Re: Quality Auto Center – *Tech Review 3*  
PA22005

## MEMORANDUM

RE: Quality Auto Center, File# PA22-005  
New Car Dealership  
15233 Smokey Point Blvd. & Parcel # 31053300205300

A1.1

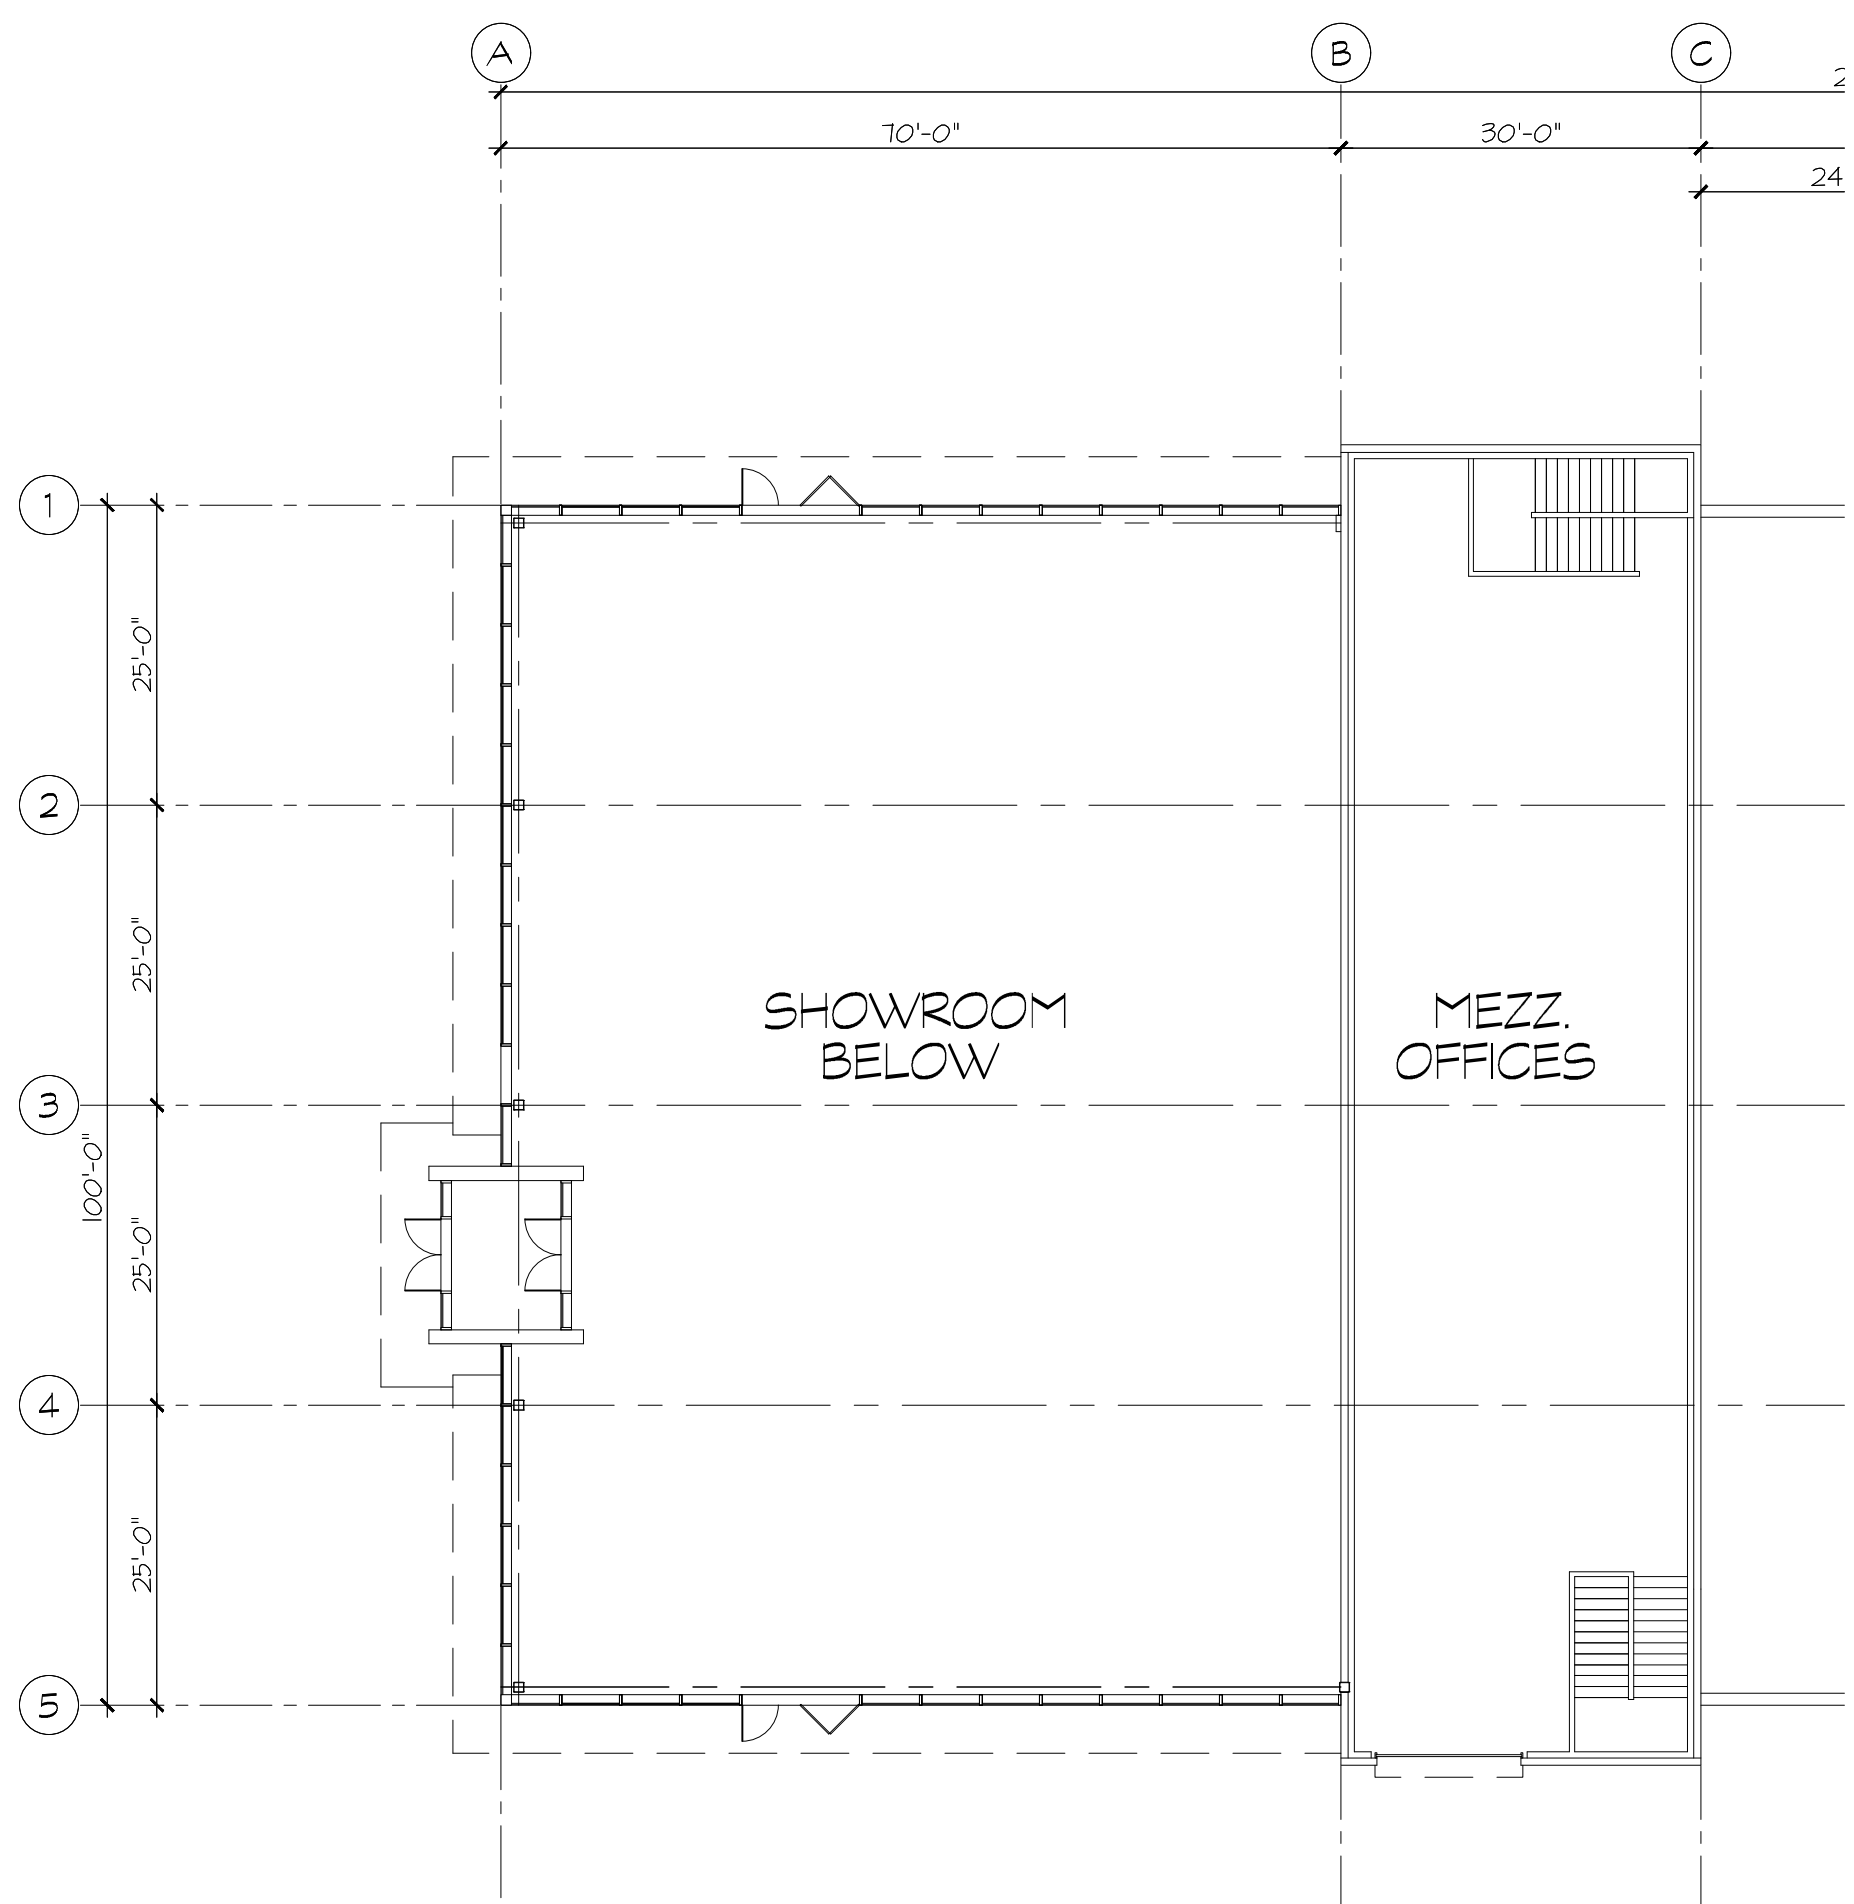
2. Pursuant to [MMC 22C.130.050\(3\)\(d\)](#), prior to civil construction plan approval, a parking lot illumination plan shall be approved, in accordance with the following design standards:

- a. 25' maximum height;
  - b. Fixtures shall be full cut-off, dark sky rated, with lower fixtures preferable so as to maintain a human scale;
  - c. Pedestrian scale lighting (light fixtures no taller than 15 feet) is encouraged in areas of pedestrian activity. Lighting shall enable pedestrian to identify a face 45 feet away in order to promote safety;

- d. Parking lot lighting shall be designed to provide security lighting to all parking spaces;
  - e. Lighting shall be shielded in a manner that does not disturb residential uses or pose a hazard to passing traffic. Lighting should not be permitted to trespass onto adjacent private parcels nor shall light source (luminaire) be visible at the property line.

- f. Fixture design shall incorporate unique design features that coincide with the architectural design of the building(s).
  - g. Also see [MMC 22C.020.250\(4\)\(d\)](#) for exterior lighting requirements.

VEHICLE TRACKING SITE PLAN

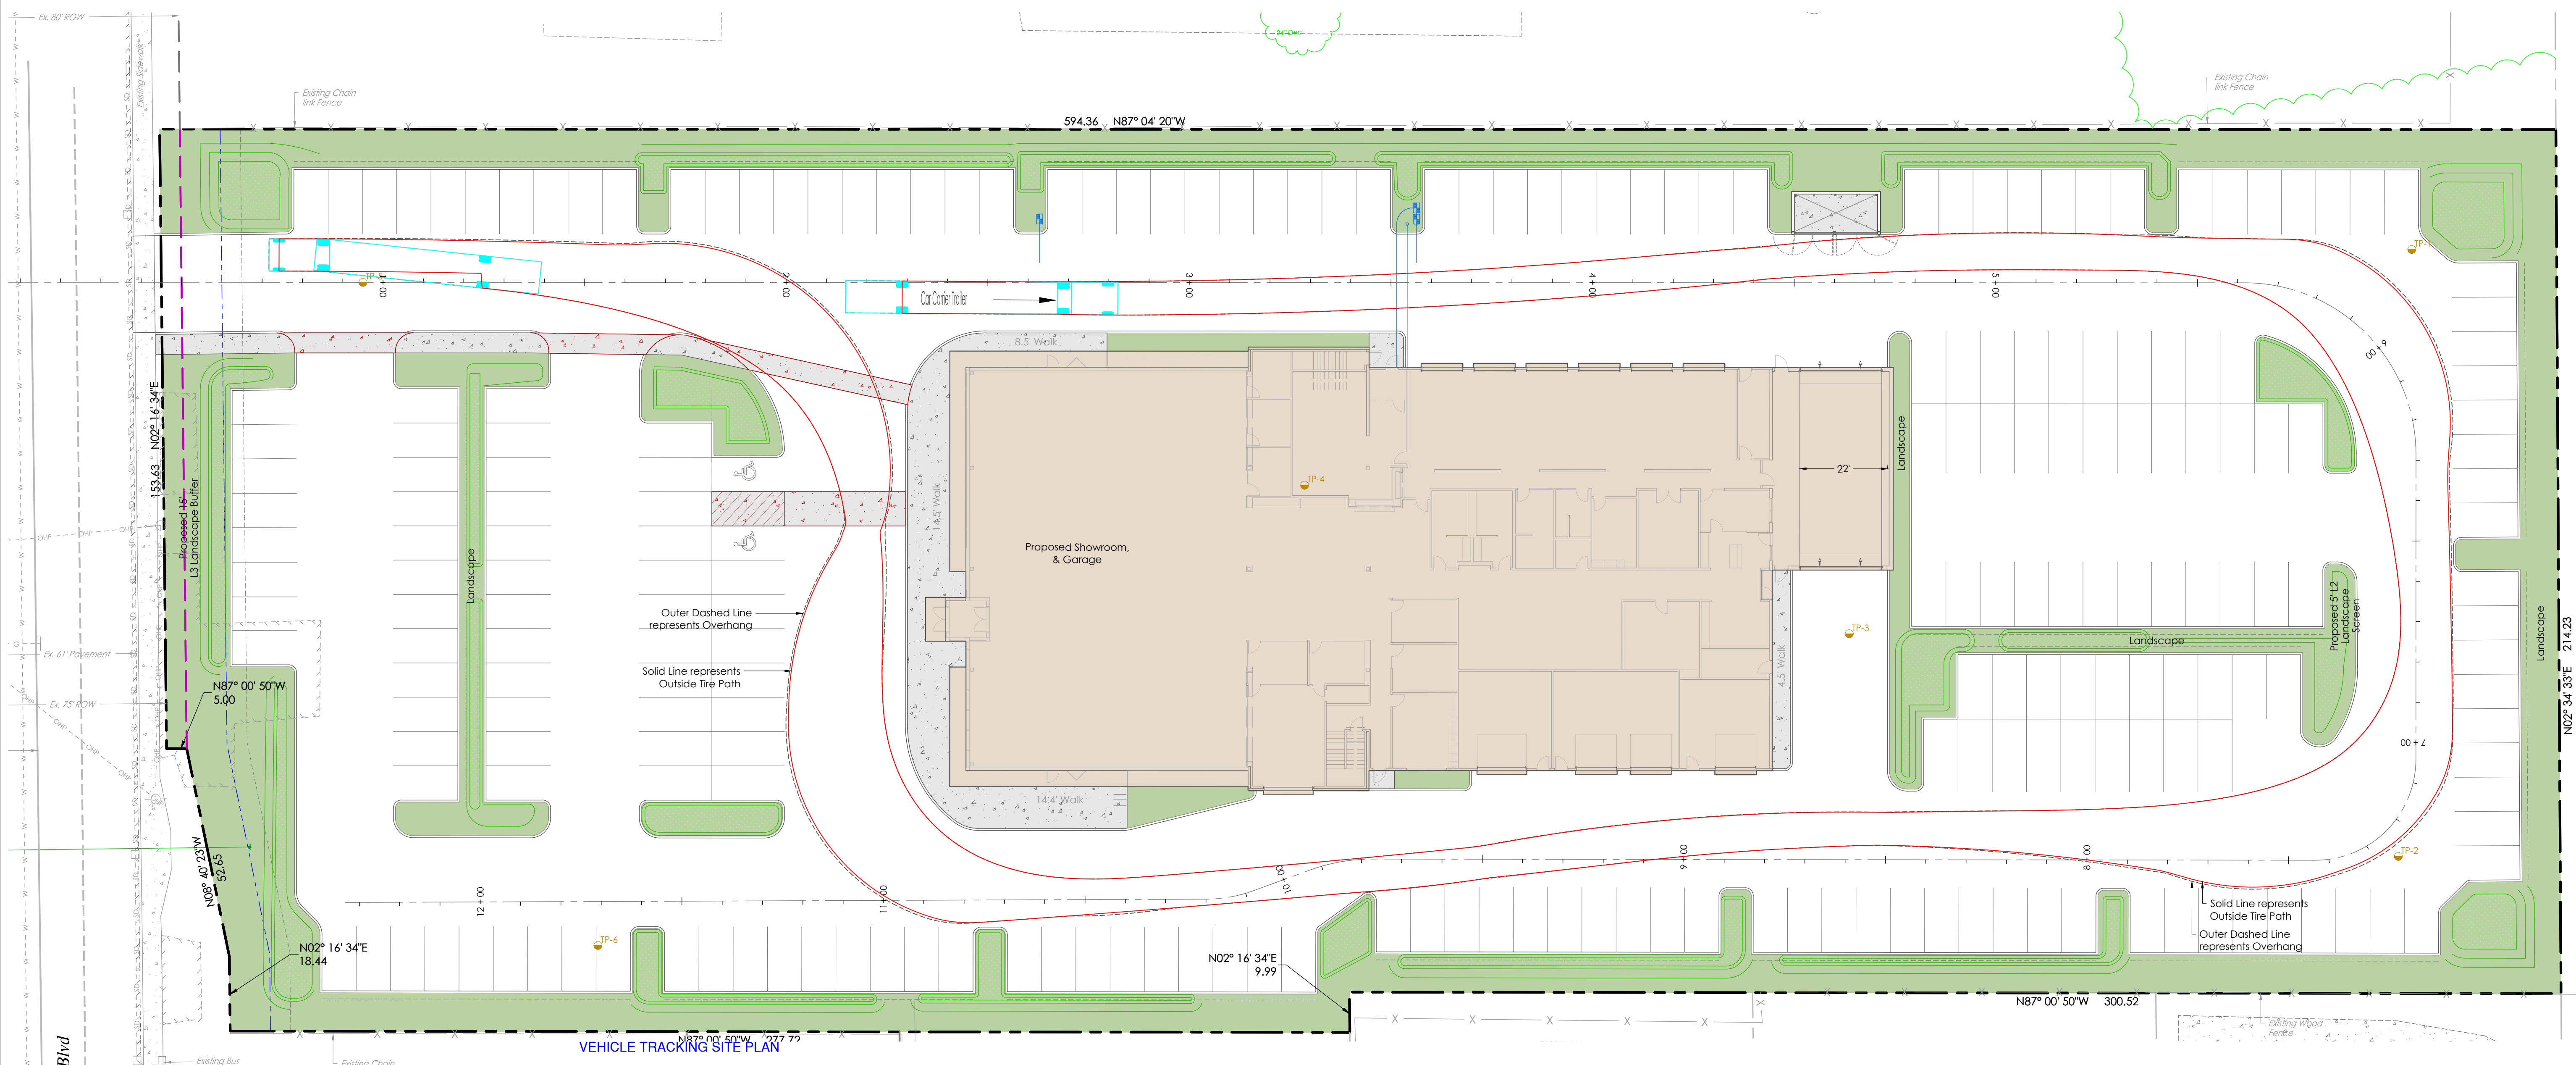
1. **Access:**
  - a. The submitted engineering variance has been approved by the Assistant City Engineer.
  - b. The location of the trash enclosure may need to be modified. It may not be accessible for the garbage trucks in the current orientation.
